BR/243/19/PL - 130 Longford Road, Bognor Regis, PO21 1AF

Further to my previous correspondence it is with regret that I have to inform you that the application has been passed up through the management on the lead up to Committee. In doing so, significant concern has been raised regarding the lack of accordance with the internal space standards. Whilst Policy D DM2 of the Arun Local Plan allows for discretion in the application of space standards in the conversion of existing residential dwellings, we use a rule of thumb of around 10% either way, in applying this discretion. In this instance, most of the apartments are nearing being 40-50% off the floorspaces outlined in the Nationally Described Space Standards. Such a deviation is too significant for the Council to be able to support.

Title
Plans as Proposed
Five Flats

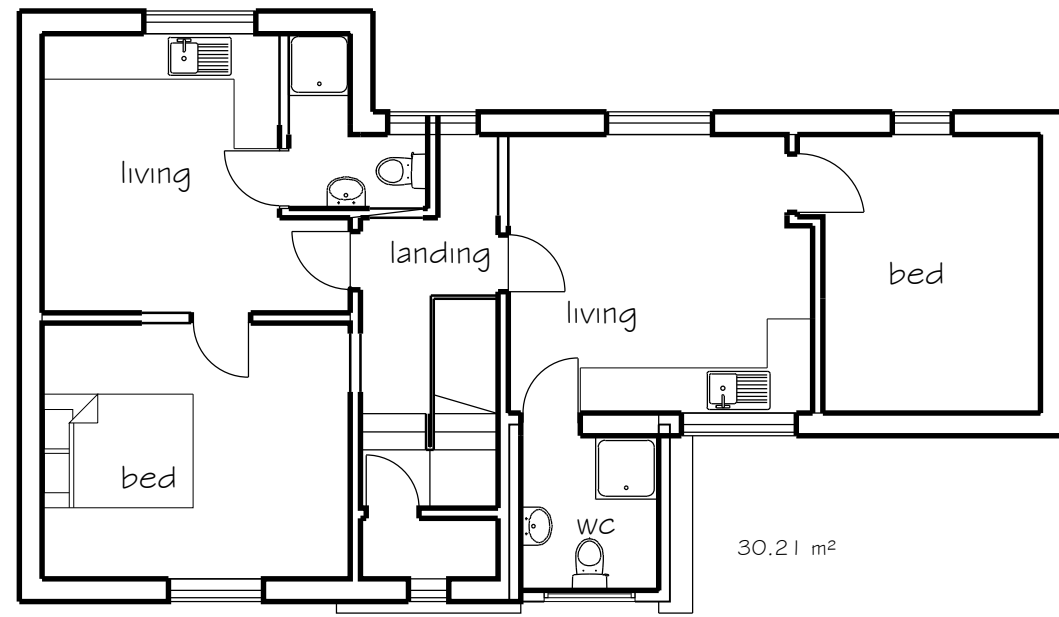
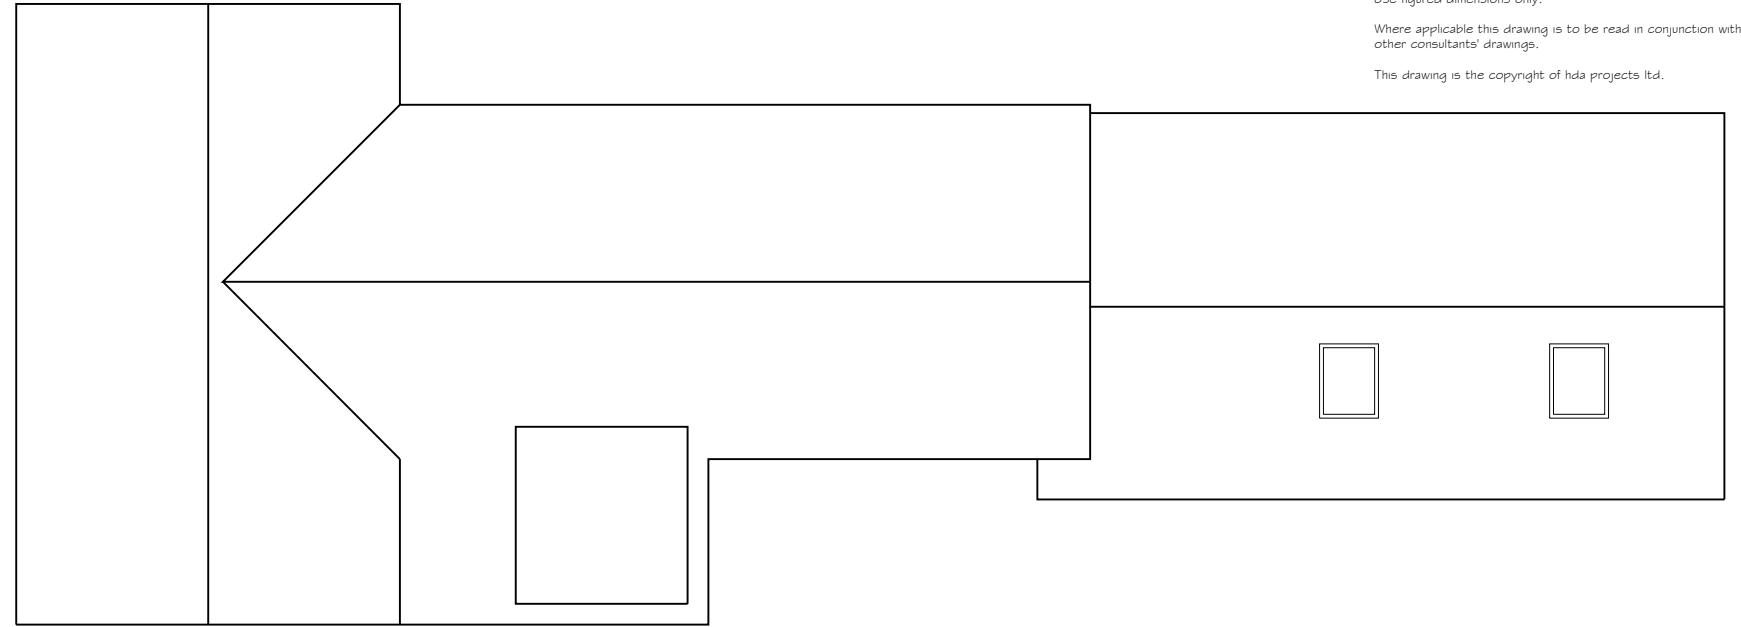
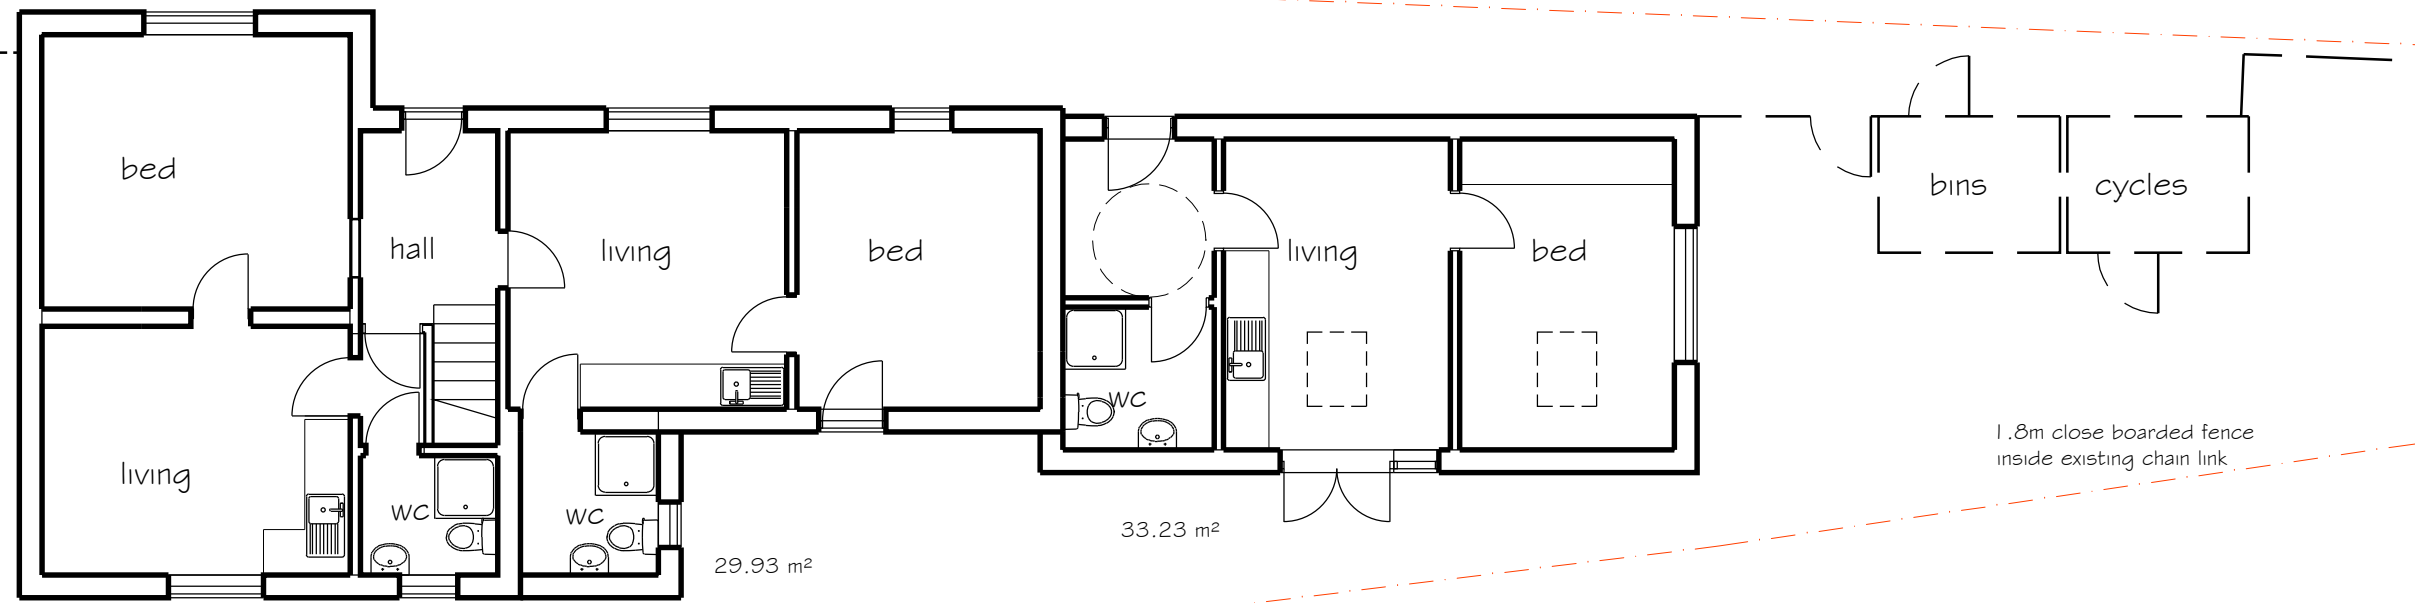
However, under this fall-back position, the development could only be used as a HMO *could* revert back to a single residential dwelling which falls within the internal space standards. If the Council were to permit 5 self-contained flats then they would always be used as 5 flats of an inappropriate size, owing to the financial values of the site. Such a permission would result in a change that would be irrevocable. With the current HMO use there is a chance that the development could be used in a manner that is deemed appropriate and in accordance with the Local Plan. There is therefore no overriding justification to permit 5 self-contained dwellings of an inappropriate standard at this stage.

Apologise I have been out this morning, I understand and have another solution, to provide only 3 units two by conversion in the existing building and a studio extension, suitable for persons with disabilities. Areas will meet DDM2 areas.
